From: Jeff Tarling
To: Helen Donaldson
CC: Barbara Barhydt ; David Margolis-Pineo
Date: 9/5/2012 3:51 PM
Subject: 433 Fore Street

Landscape & tree comments for the proposed 433 Fore Street project:

LANDSCAPING AND SITE AMENITIES PLAN

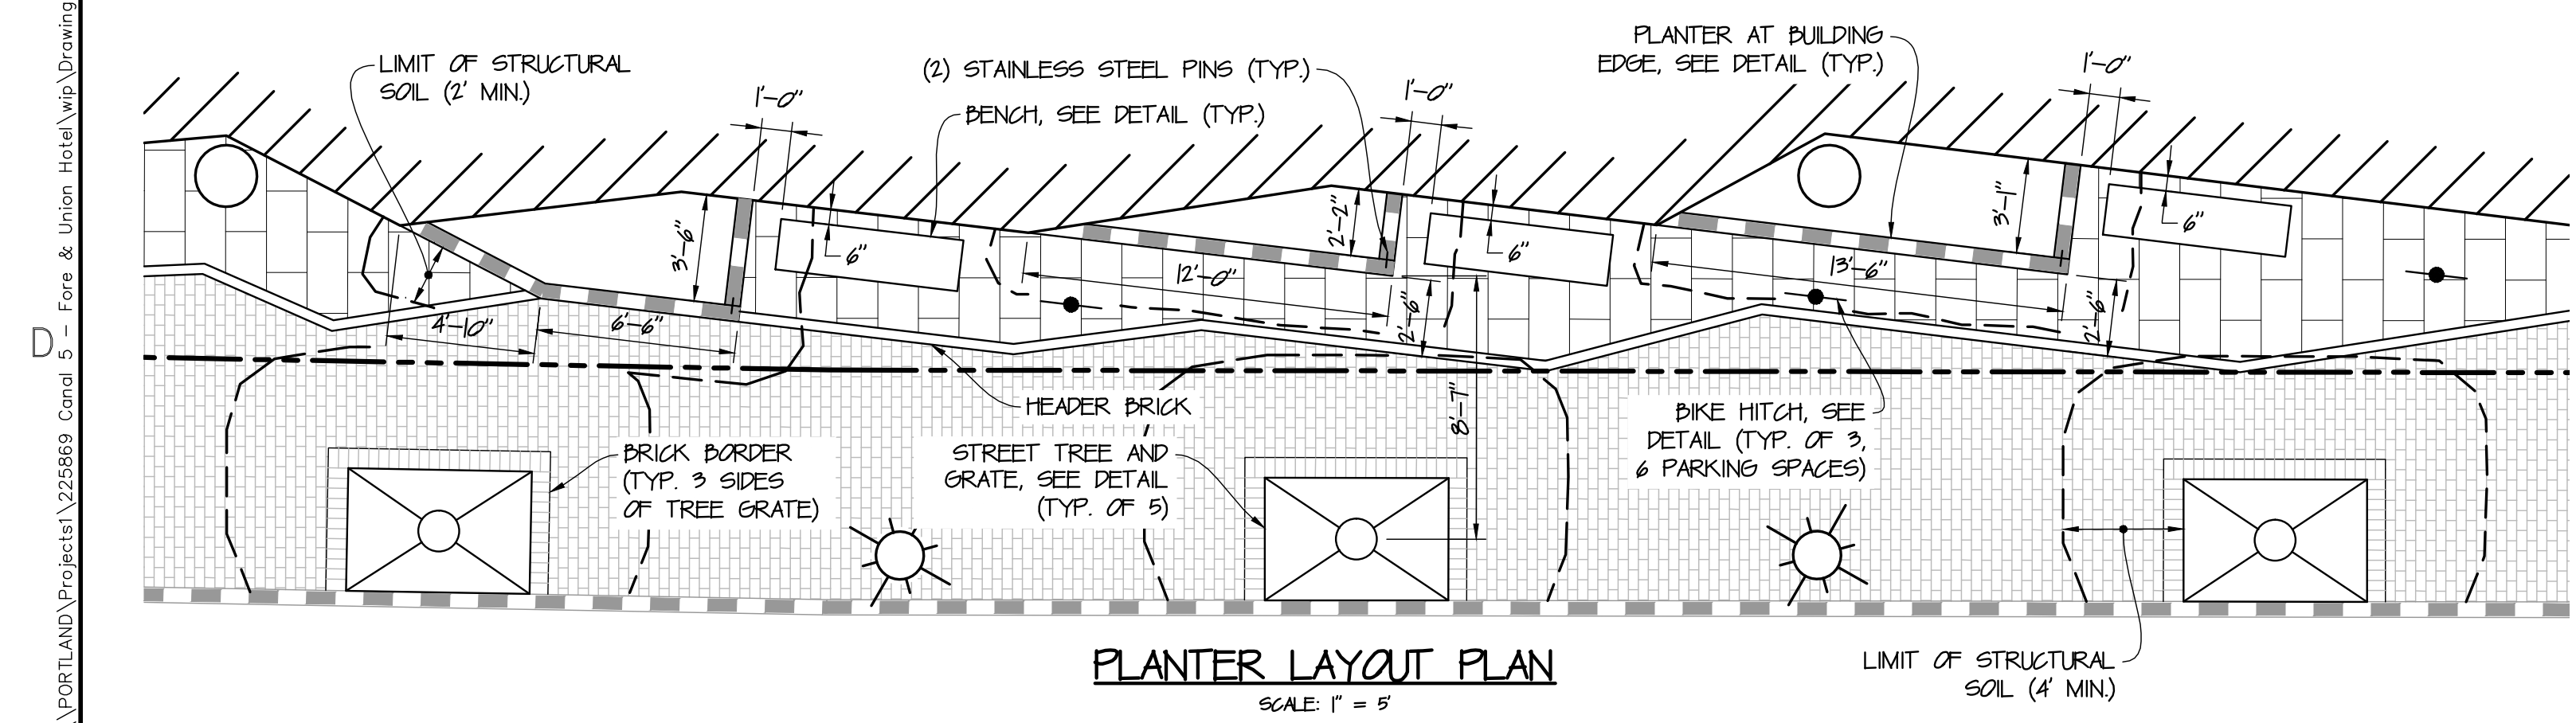
The proposed hotel building occupies a large percentage of the overall project site leaving little if any landscape space presented. Recommendations would be to create landscape space as available along the building wall behind the sidewalk along Fore Street and Union Street. This may include woody & herbaceous planting in raised beds, planters and streetscape improvements. The goal would be to meet landscape standards and the typical horticultural displays found at similar hotel projects the use of raised planters should be included. Recommendations / conditions would include installing raised granite planters along both Fore & Union Streets that include both street-trees and some type of landscape planting, such as low woody / herbaceous planting. The use of 'green wall' vertical planting system should be explored for non-window areas. The environmental benefit of greenwalls, landscaping should be considered an important element for the site even with limited planting space.

Landscape buffer for CMP substation - the boarder between the existing CMP substation and the proposed hotel project should include a buffer between the two sites. This could include the use of fencing and vegetation. The applicant should work with CMP to continue the long existing screening of the substation that includes trees and shrubs. This would include the service entrance from Canal Plaza. Outdoor storage or dumpsters would need to have a landscape treatment if proposed (unsure if this is planned for indoors and the basement level).

Landscape Plan Sketch

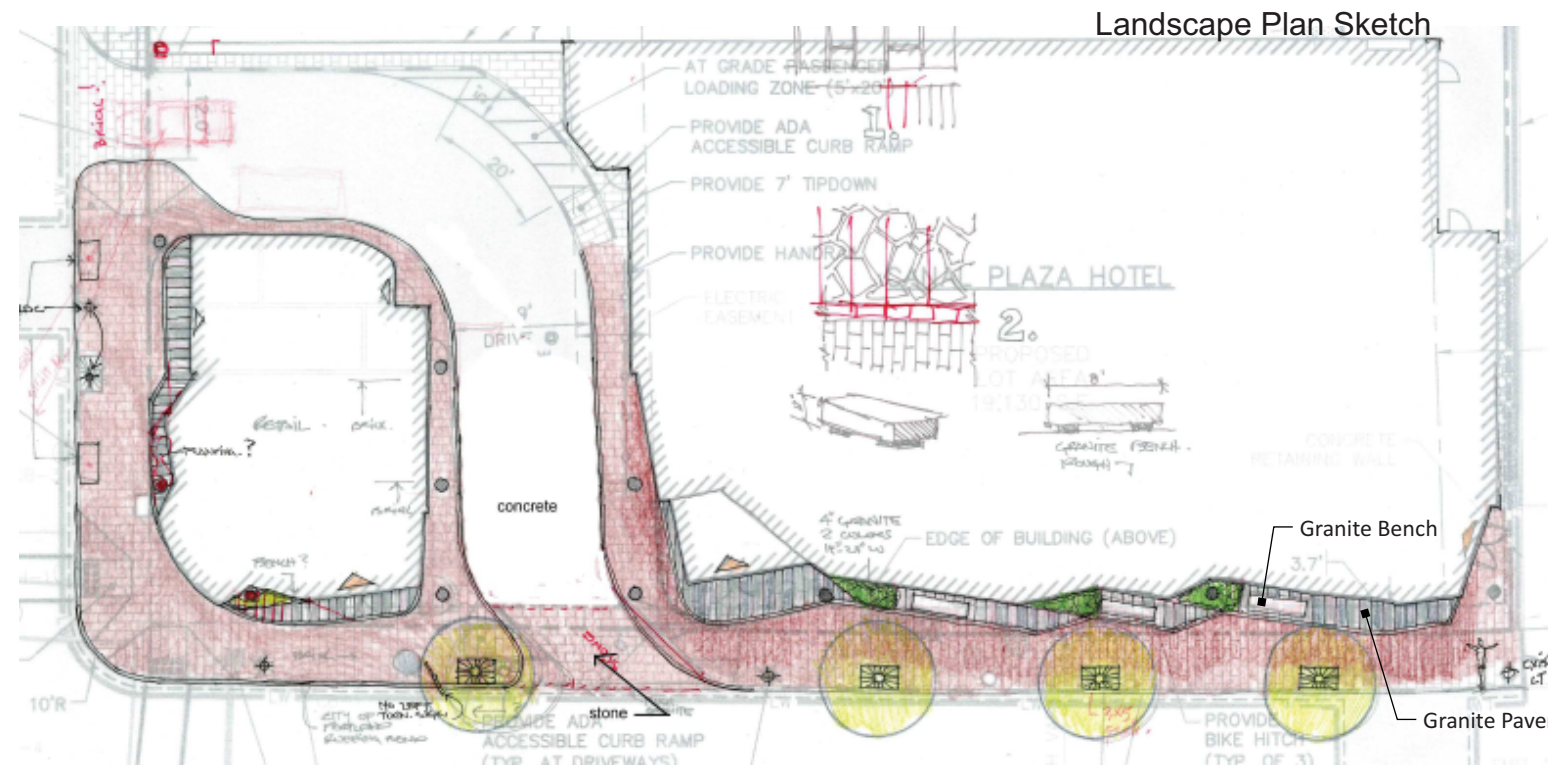
In review, the proposed hotel project at 433 Fore Street would benefit from the inclusion of improved streetscape view horticultural / landscape elements that would be both environmentally and visually important for the site.
